RE: Flood Action Plan - Fanuc House, 1 Station Approach, Ruislip HA4 8LF

Thank you for your comments on the Flood Action Plan dated September 2018 relating to the new residential development at the above site. I have updated the Flood Action Plan to address your comments and the latest version is dated November 2020.

Figure 6: Evacuation Route and EA Floodmap for Planning

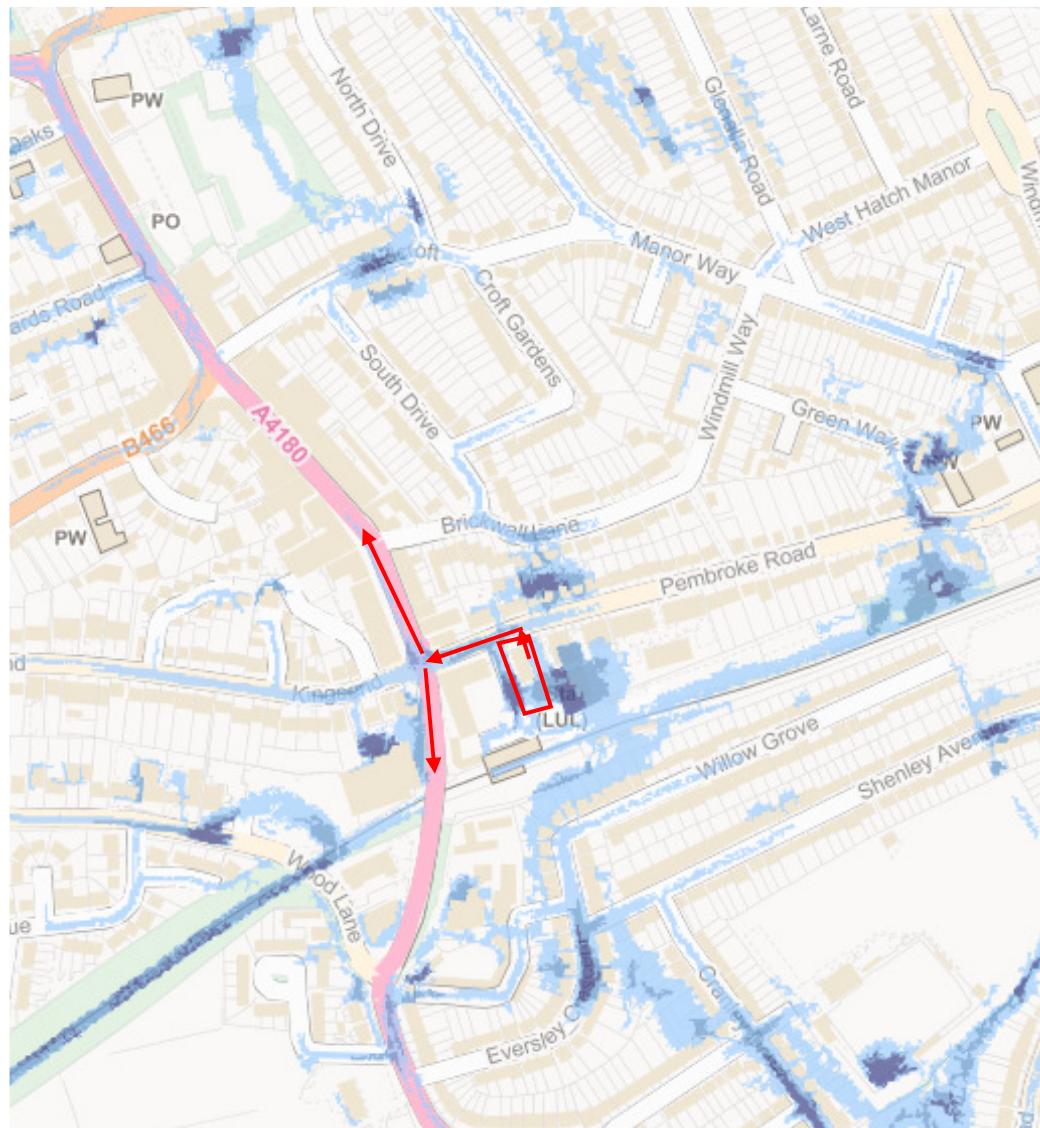
The Evacuation Route in Figure 6 is towards the 'low risk' surface water zone as this is the quickest route away from the flooded areas. If the evacuation route was to the east along Pembroke Road, it would be towards 'high risk' zones and further flooded areas.
